FW: Planning Application FG/105/25/PL - Yeomans House, Littlehampton

Subject: Planning Application FG/105/25/PL - Yeomans House, Littlehampton

Client: Yeomans
 Date: August 2025
 Scale: 1:200 @ A1
 Project: Proposed Mazda, Littlehampton Road, Ferring, Worthing, BN12 6PB
 Drawing Title: Proposed Site Plan

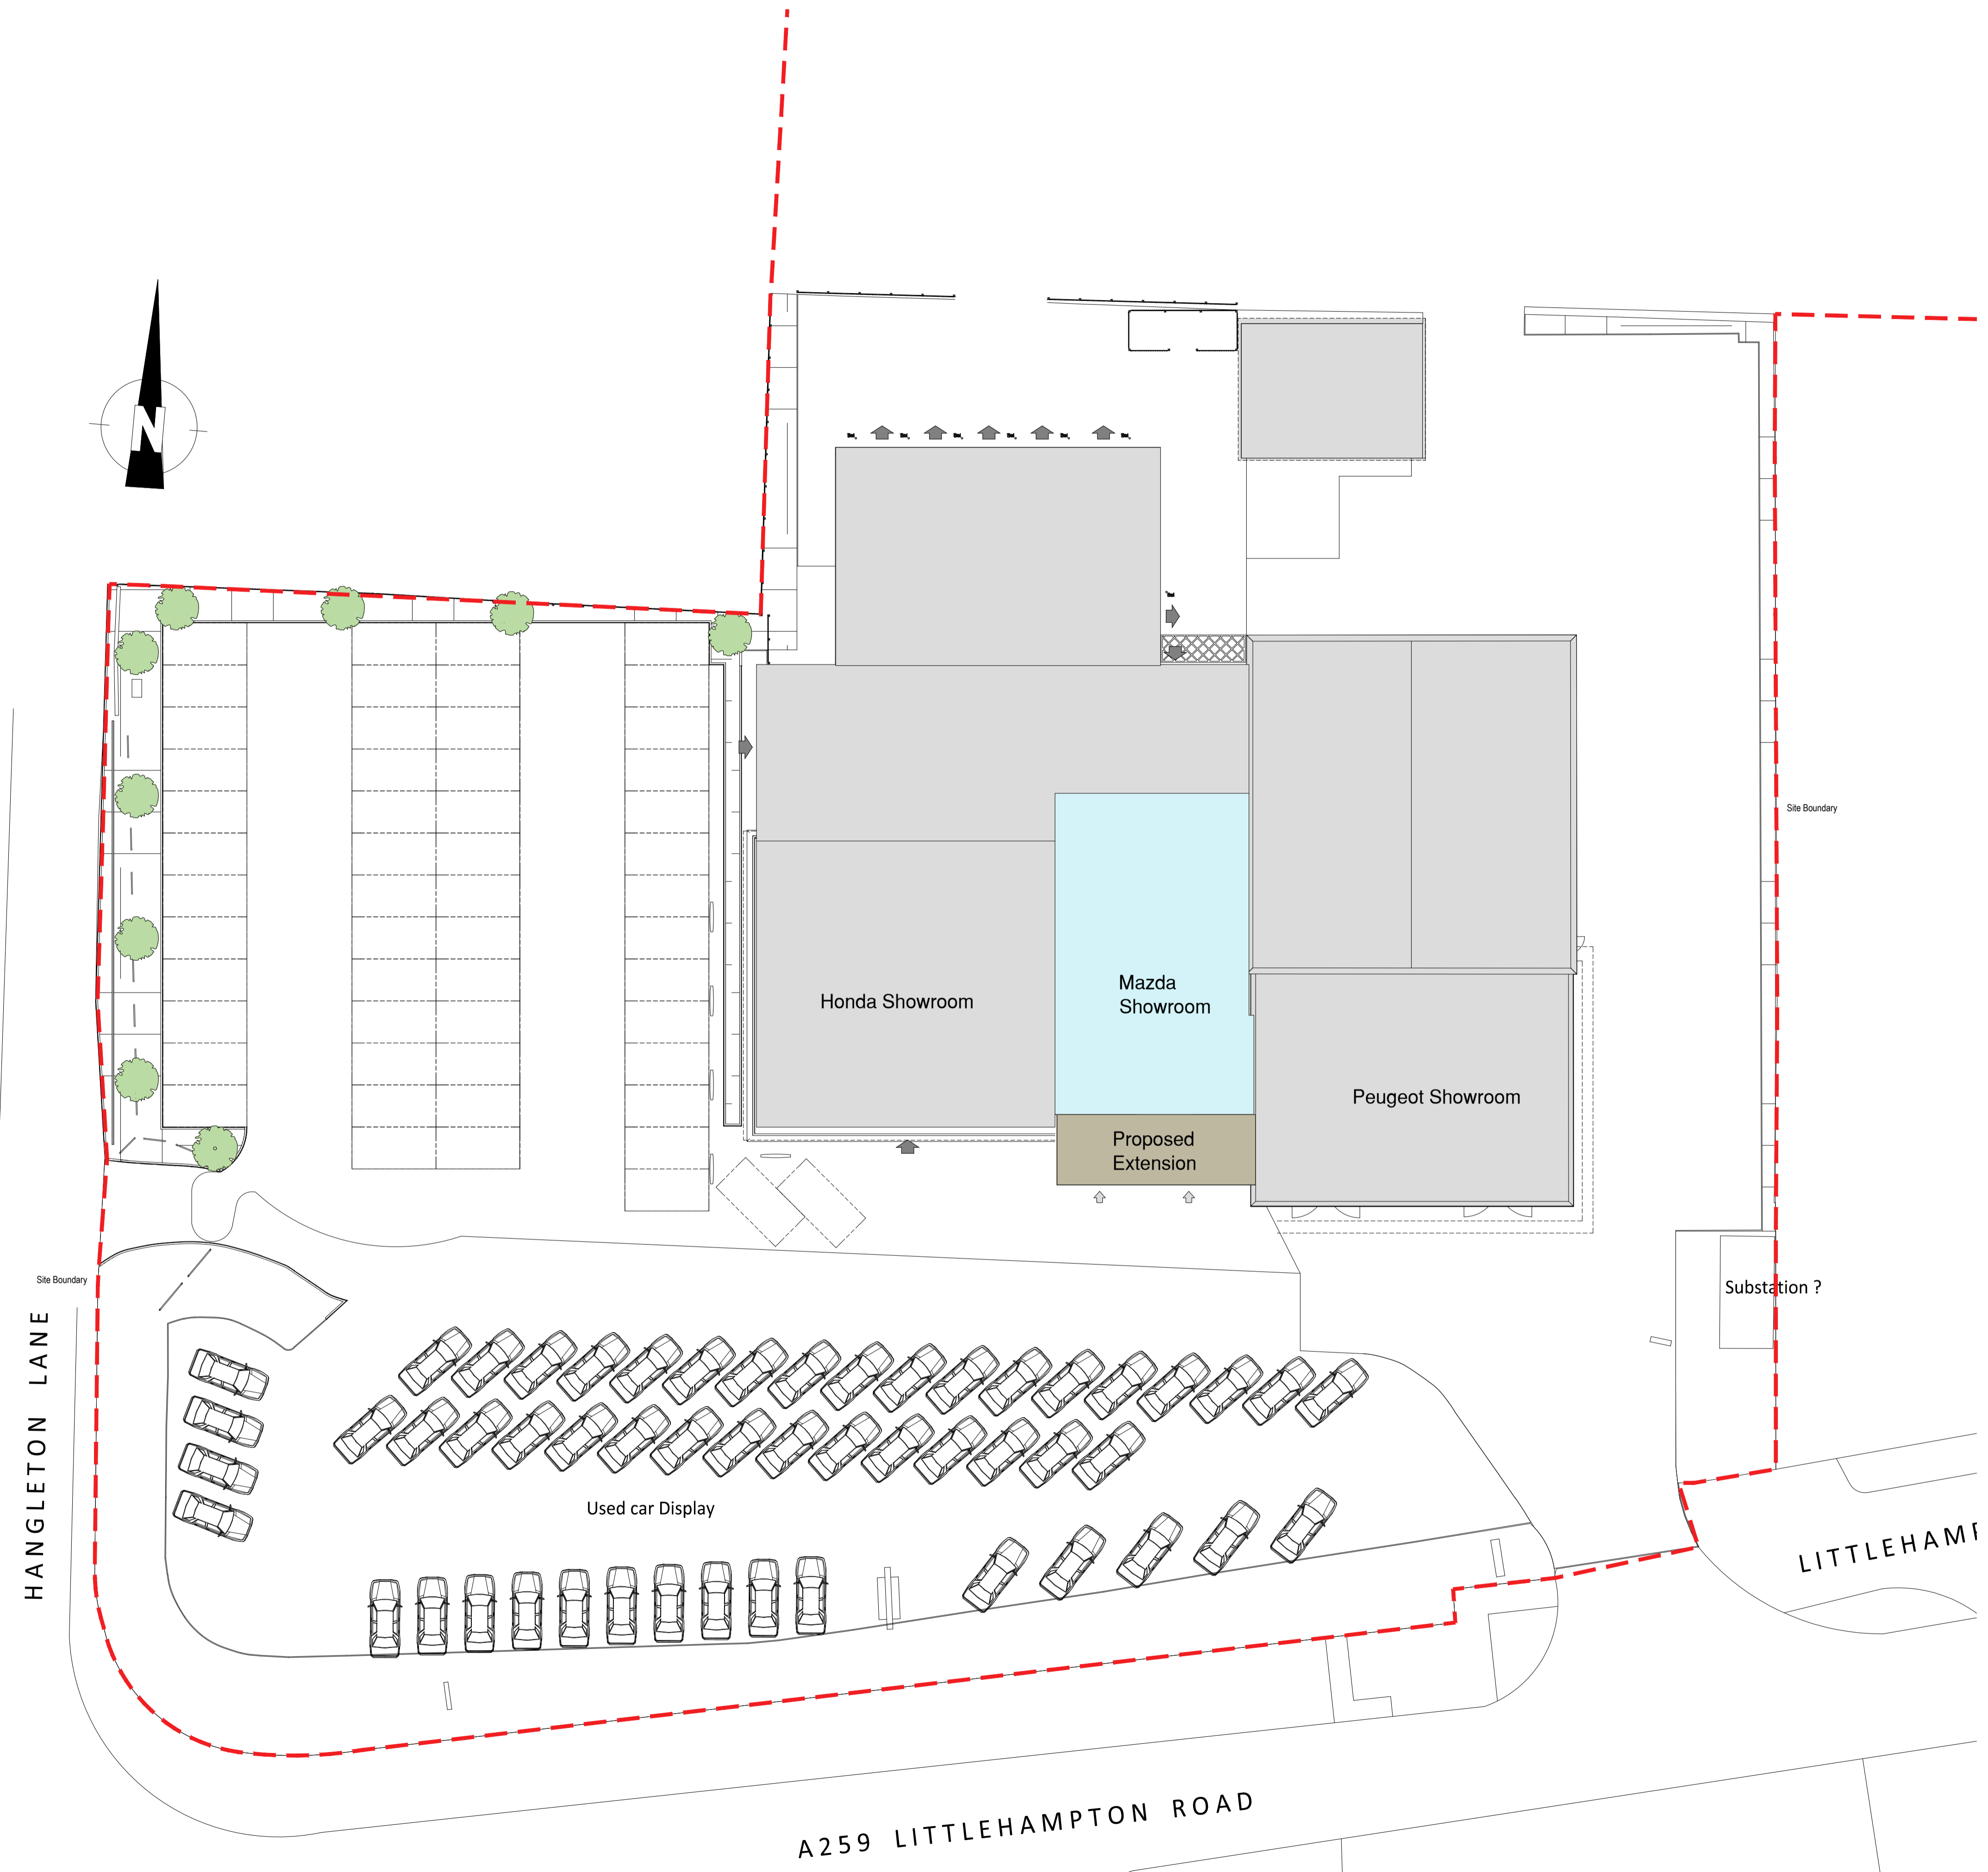
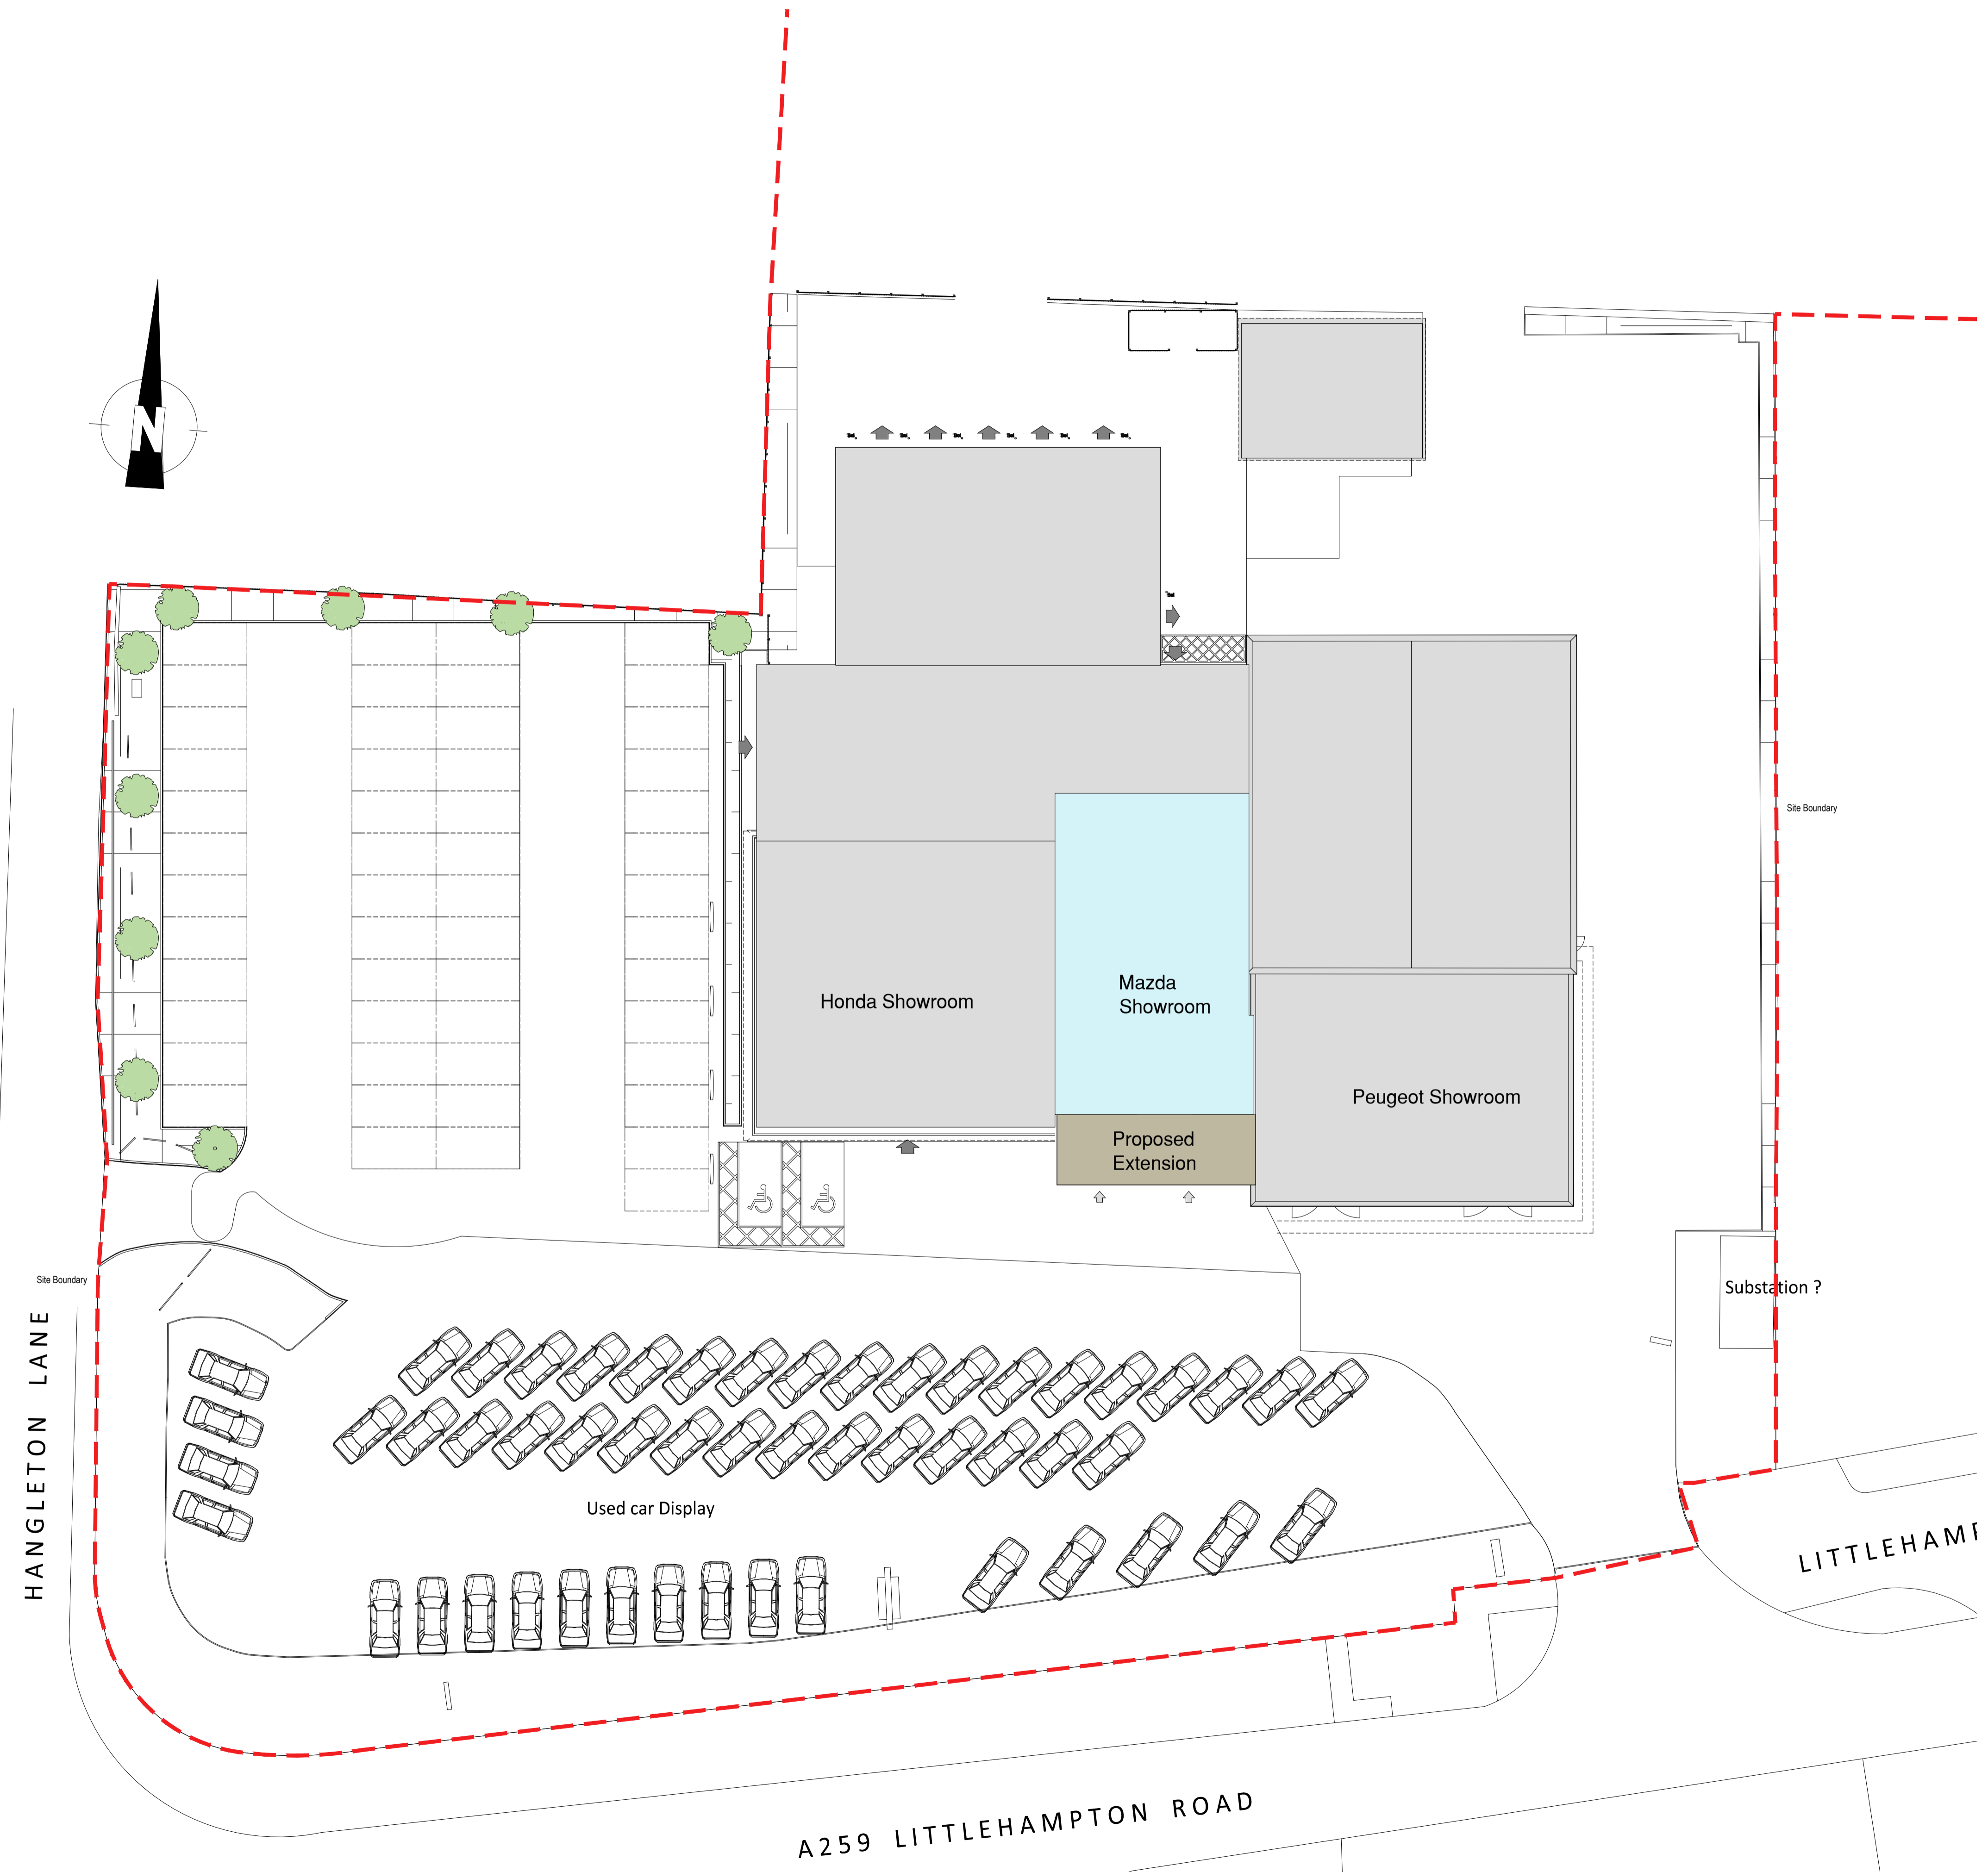
I have received comments from Ferring Parish Council in relation to the application above. They have no objection subject to the reattachment of a condition concerning deliveries, and the continued provision of sufficient disabled parking spaces. I note from the plans that there are two disabled parking bays which would be lost following the extension. Please could you confirm whether these parking spaces will be replaced elsewhere on site?

We can confirm that the 2 disabled spaces are to be relocated as indicated on the amended Site Plan attached.
